Article 21 of the Town and Country Planning (General Development Procedure) Order 1995
Application for approval of matters reserved by condition imposed under A/143/14/L relating to
Condition 2 - window joinery
White House Cottage High Street, Angmering,

Arun District Council have decided to **REFUSE details reserved by condition for the following reasons:**

FLOATING Mullion Detail - Mayfield Sash (15mm)

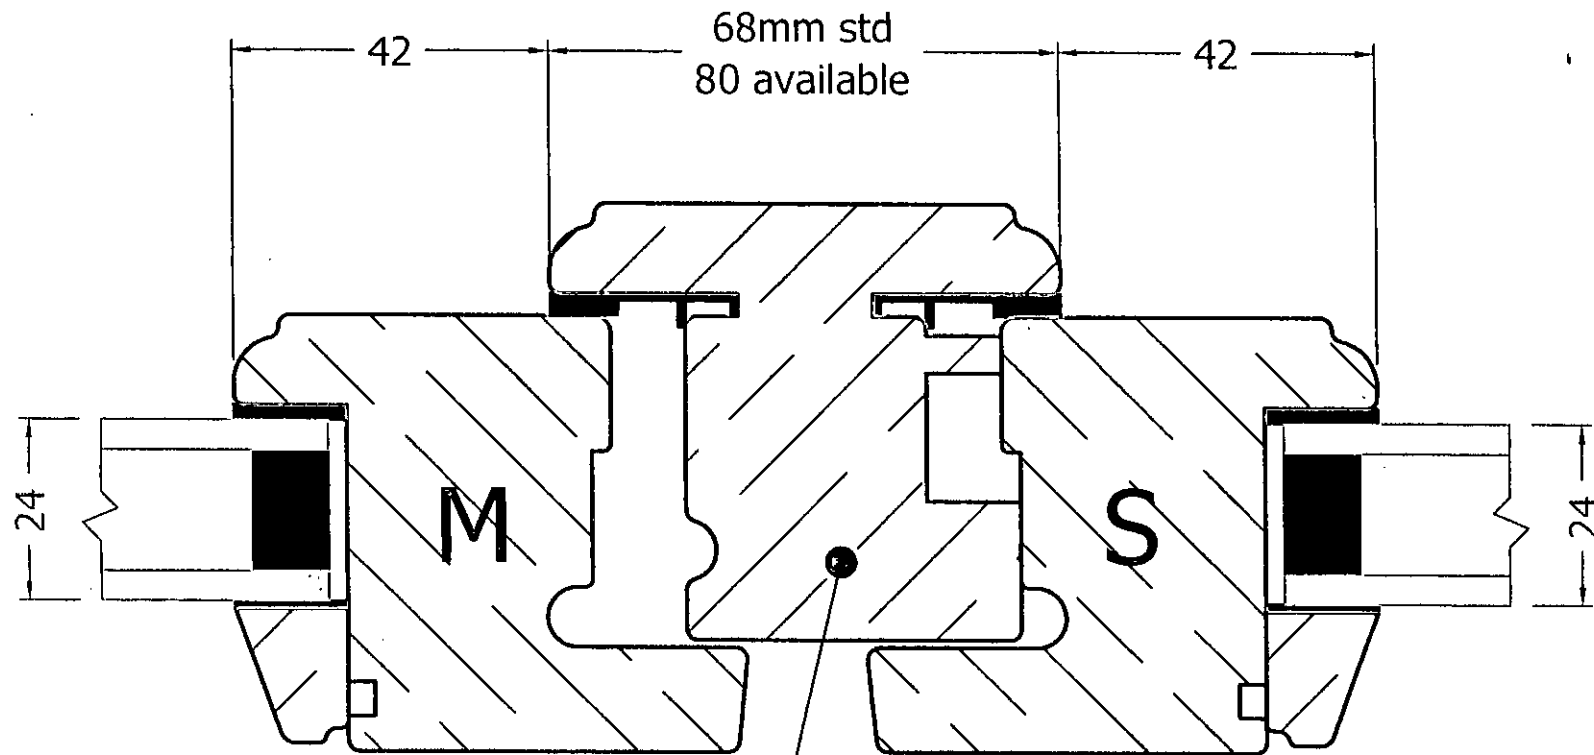
The window details are not acceptable for use on historic buildings. The casement should be flush and not 'storm' and the glazing should be single glazed as requested at application stage.

This design will appear overly bulky and unsympathetic to the building character.

You are advised to contact the Council's Historic Buildings adviser for guidance on this point. His contact details are - iwightman@chichester.gov.uk & Tel: 01243 785 166.
